Response to Planning Application

Application ref: WA/79/20/PL

Description: Demolition of existing dwelling & erections of 8 No. new dwellinghouses with associated landscaping & parking (resubmission following WA/30/20/PL). This application is a Departure from the Development Plan & is in CIL Zone 3 and is CIL Liable.

Location: Spindlewood Yapton Lane Walberton BN18 0AS

Drawing No.
DPA 02

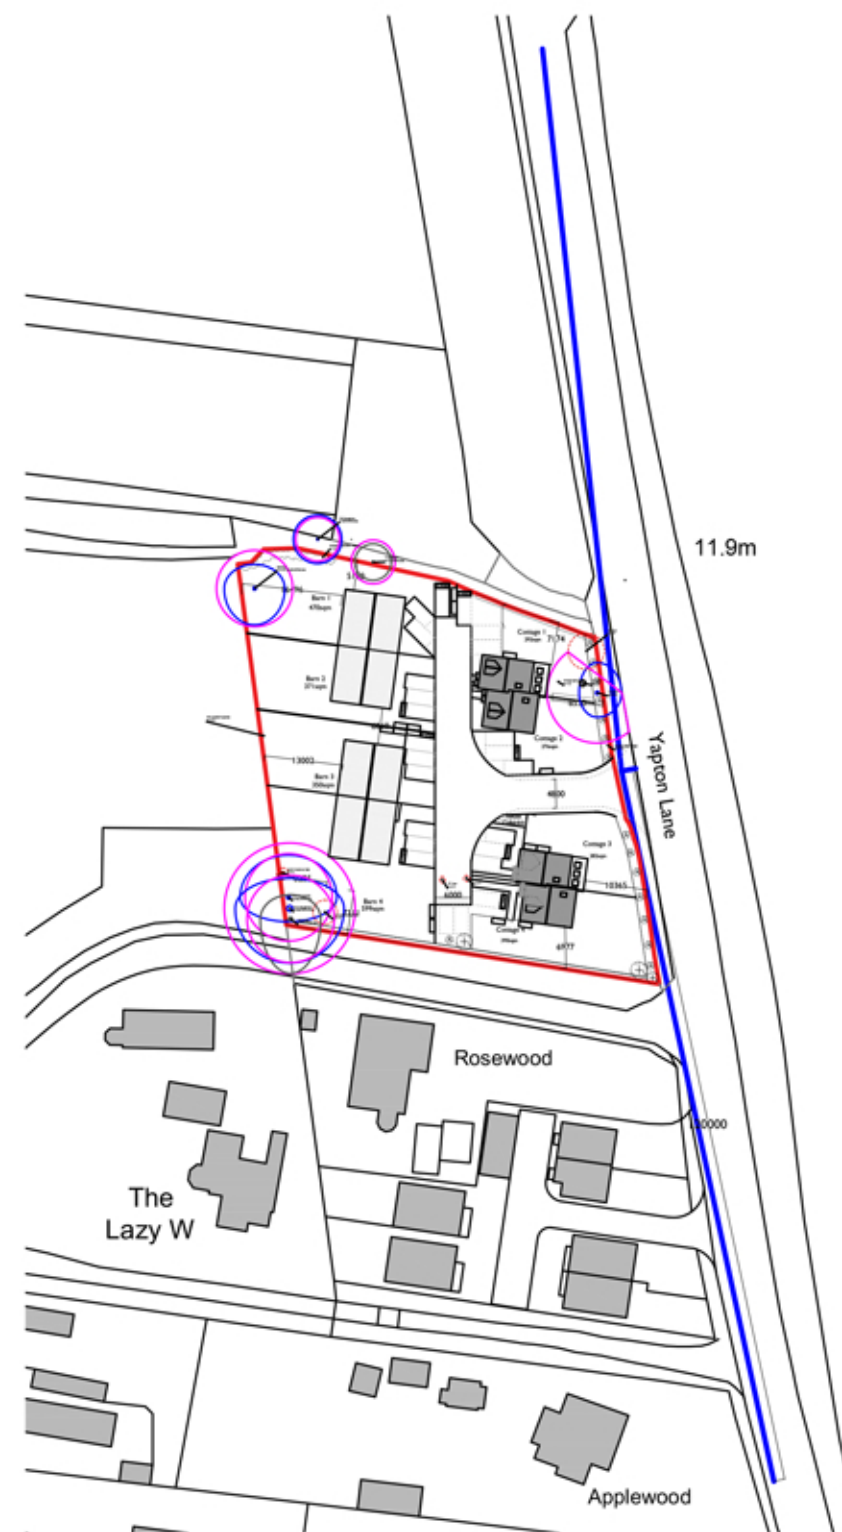
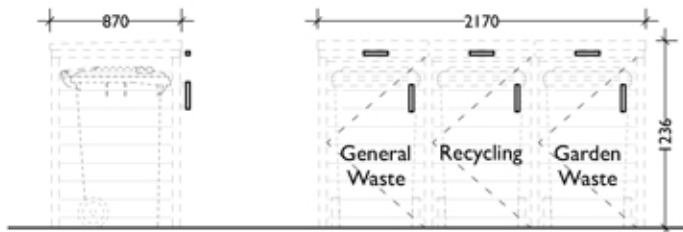
The proposed Site Plan Dwg No DPA 02 shows indicative landscape proposals which would need to be confirmed in plan form to show existing to be retained and new planting detailing species choice, actual quantities, planting densities and size at time of planting. The position of the proposed dwellings along Yapton road would appear to face into the site which would require fencing along the road frontage. This

would create a harsh barrier along this roadway where properties fronting the road with suitable green buffer frontage would be more desirable/aesthetic on the street scene.
